Historic England

**REPRESENTATIONS OF THE HISTORIC BUILDINGS AND MONUMENTS
COMMISSION FOR ENGLAND (HISTORIC ENGLAND)**

**APPLICATION BY NATIONAL HIGHWAYS FOR AN ORDER GRANTING
DEVELOPMENT CONSENT FOR THE PROPOSED A12 CHELMSFORD TO A120
WIDENING SCHEME**

Written Representation: Historic England

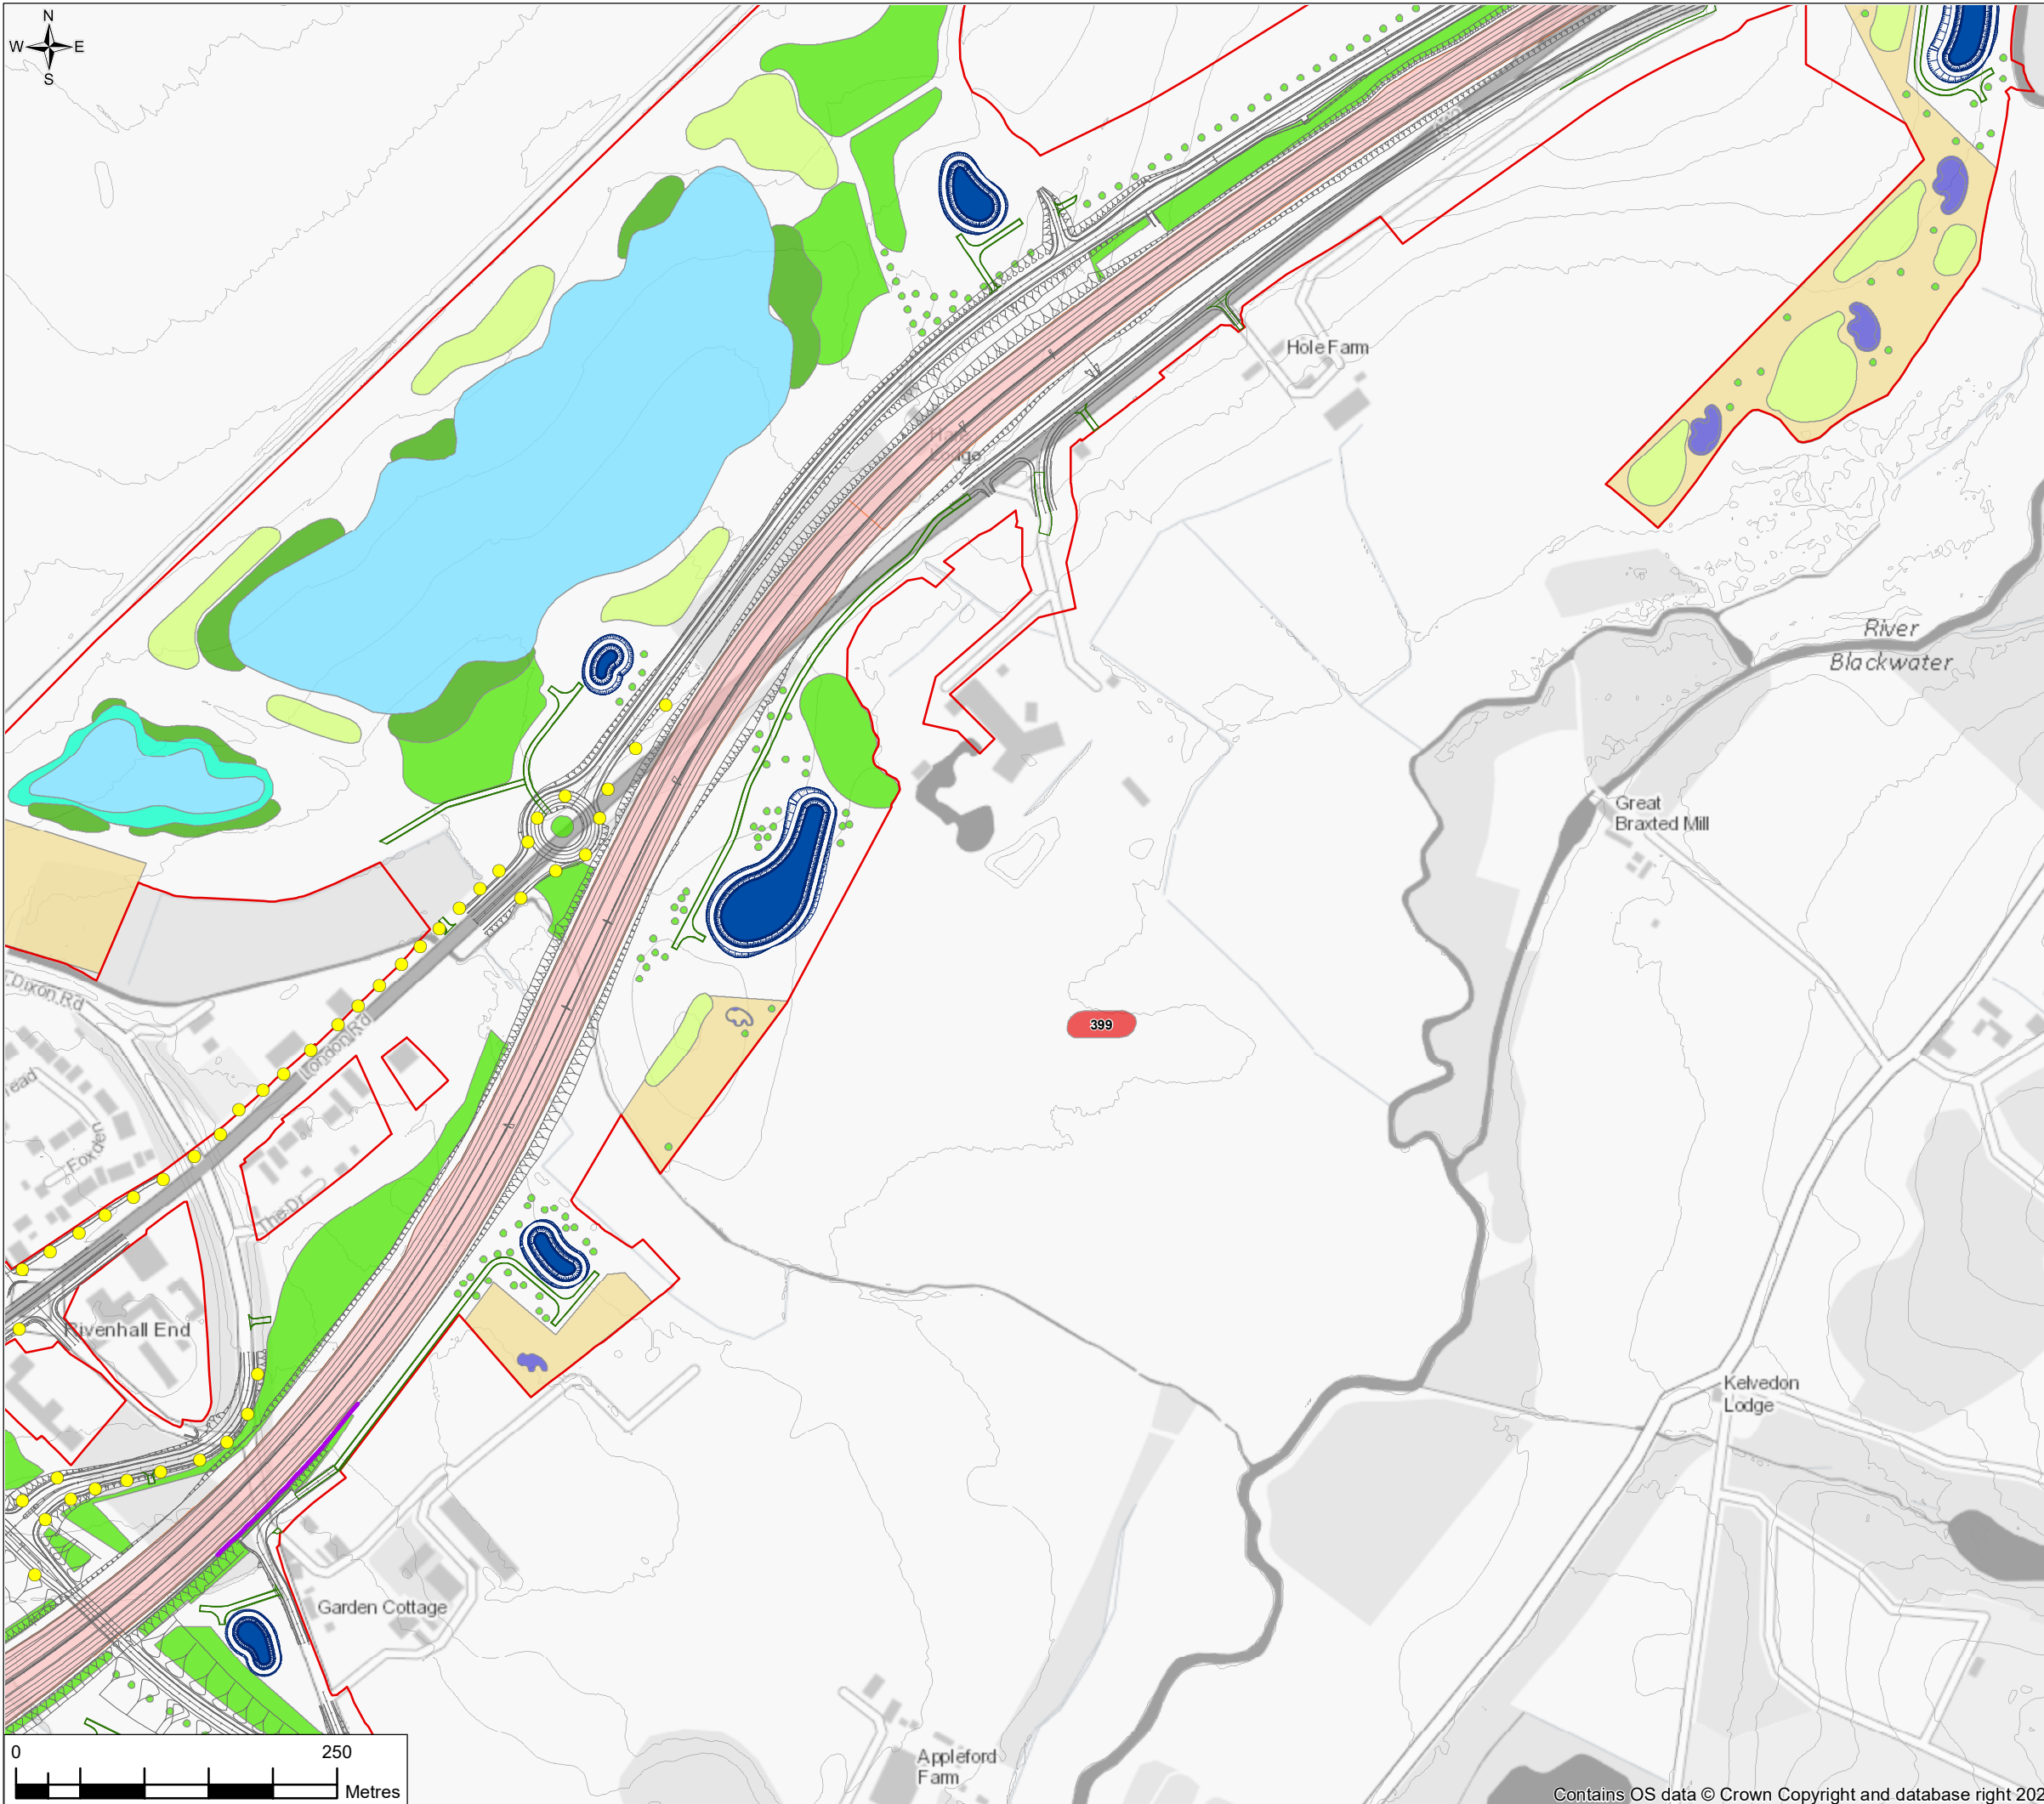
5.3.1 In terms of the impact on the scheduled monument known as 'Neolithic long mortuary enclosure at Appleford Farm, Rivenhall End' (NHLE 1008980), we note that a new offline and embanked section of road will be constructed in the field to the north of the monument.

- 5.3.2 A large drainage attenuation and water treatment pond, as well as ecological ponds and planting, is proposed between the new offline road and the scheduled monument.

- 5.3.4 We do not accept this assessment of the impact of the proposed offline road section on the significance of this scheduled monument. We consider the setting of the scheduled monument contributes positively to its significance. We consider the setting of the monument will be affected by construction and also operation of the new offline road section.

- 5.3.6 The current line of the A12 is set down in a slight cutting c.400m to the north, partially hidden from view of the scheduled monument. The proposed development will require the construction of major new earthworks - a new embanked and offline section of road that would be closer to the scheduled monument, in the field immediately to the north (ES Figure 2.1 Environmental Masterplan CH. 23900 TO 25100, Sheet 11 of 21).

- 5.3.7 We consider the proposed construction of the road on an embankment to the north of the scheduled mortuary enclosure, along with associated landscaping works, would result in a substantial change to the context of the monument. In our view, this would result in harm to the significance of the scheduled monument known as 'Neolithic long mortuary enclosure at Appleford Farm, Rivenhall End', both during construction and operation. Placing this in terms of the National Networks National Policy Statement (NPSNN) we conclude that this would be a high degree of 'less than substantial' harm under paragraph 5.134.

- 5.3.8 We recommend the assessment of the setting of, and impact of the proposed development on, this scheduled monument is reconsidered by the applicant and, where appropriate, the document revised and reissued for examination. This is because the setting makes a positive contribution to the significance of this monument and because the proposed development will result in a significant change to the setting.

- 5.3.10 We would recommend that proposals should be put forward by the applicant to mitigate the impact of the offline section of road on the significance of the scheduled monument.
